**United Utilities Water Limited
Developer Services & Metering**
2nd Floor, Grasmere House
Lingley Mere Business Park
Lingley Green Avenue
Warrington
WA5 3LP

Your ref: 3/2019/0132
Our ref: DC/19/949
Date: 05-MAR-19

Location: Parcel 4 Land to the west of Malt Kiln Brow Chipping PR3 2GP
Proposal: RM- approval for the residential development of four new dwellings with associated infrastructure

# Site Layout - Parcel 4, Chipping

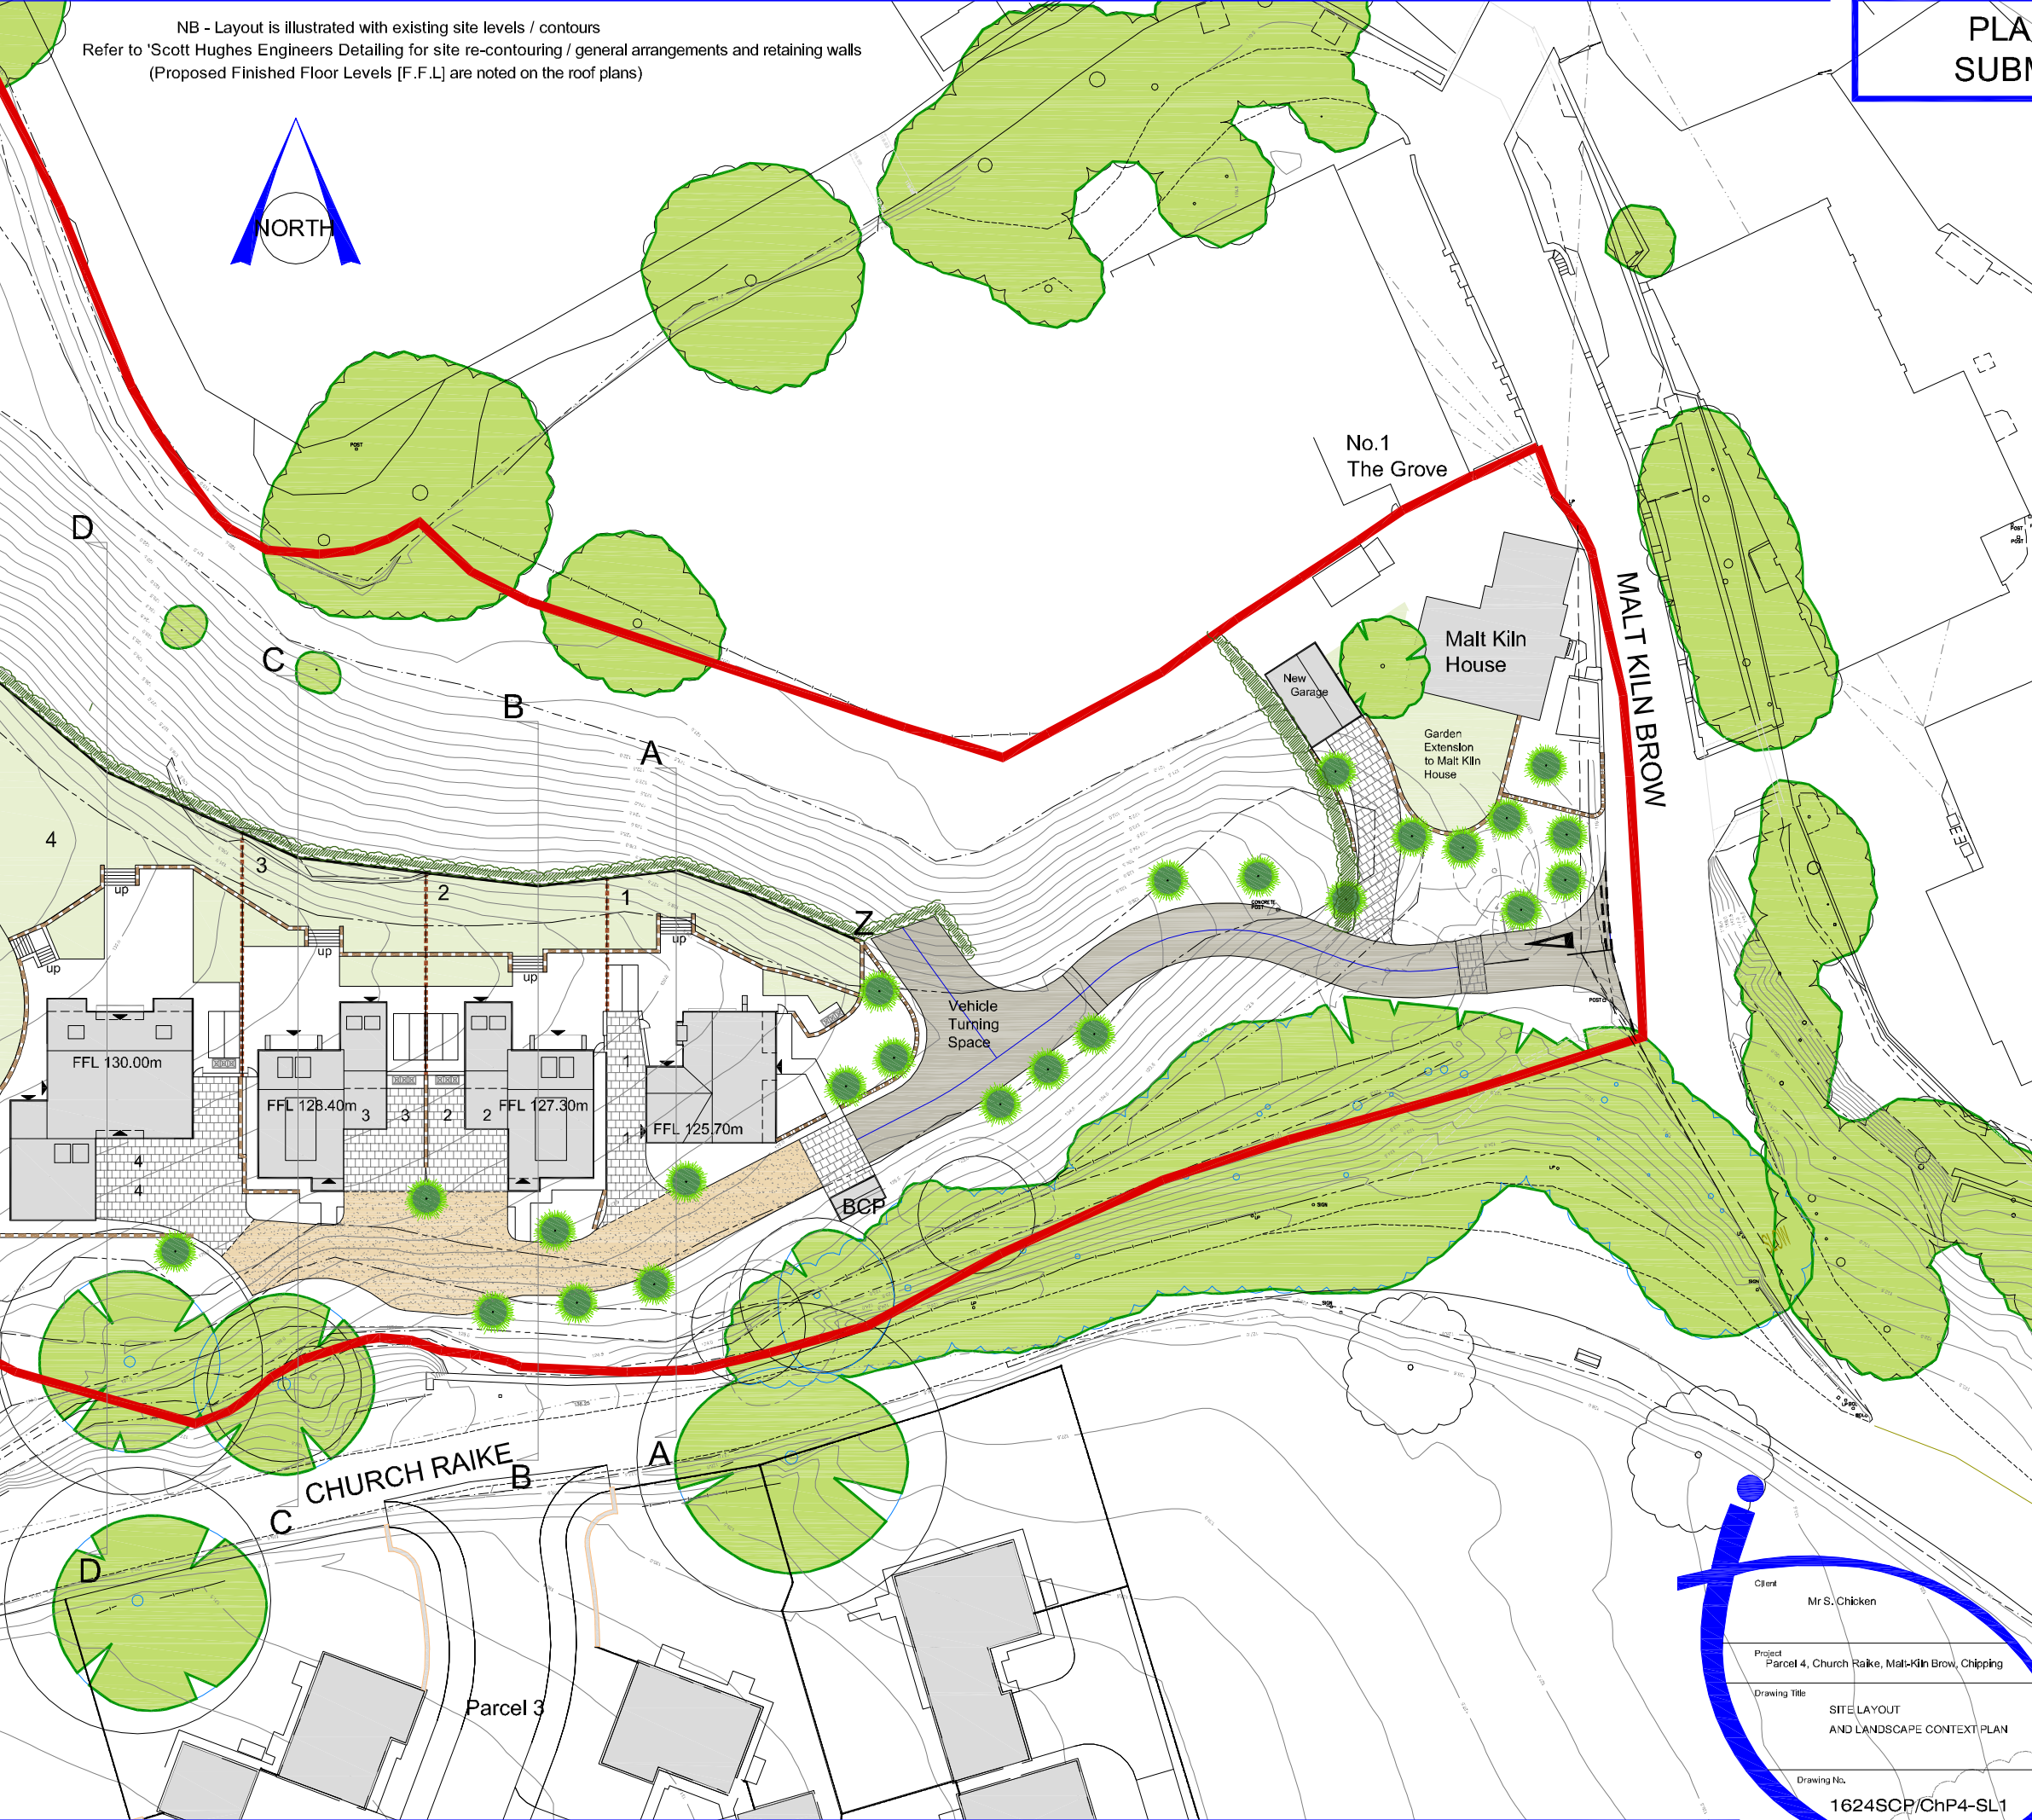
A public sewer crosses this site and we may not permit building over it. We will require an access strip width of six metres, three metres either side of the centre line of the sewer which is in accordance with the minimum distances specified in the current issue of "Sewers for Adoption", for maintenance or replacement. Therefore a modification of the site layout, or a diversion of the affected public sewer at the applicant's expense, may be necessary. To establish if a sewer diversion is feasible, the applicant must discuss this at an early stage with our Developer Engineer at

wastewaterdeveloperservices@uuplc.co.uk as a lengthy lead in period may be required if a sewer diversion proves to be acceptable.

Deep rooted shrubs and trees should not be planted in the vicinity of the public sewer and overflow systems.
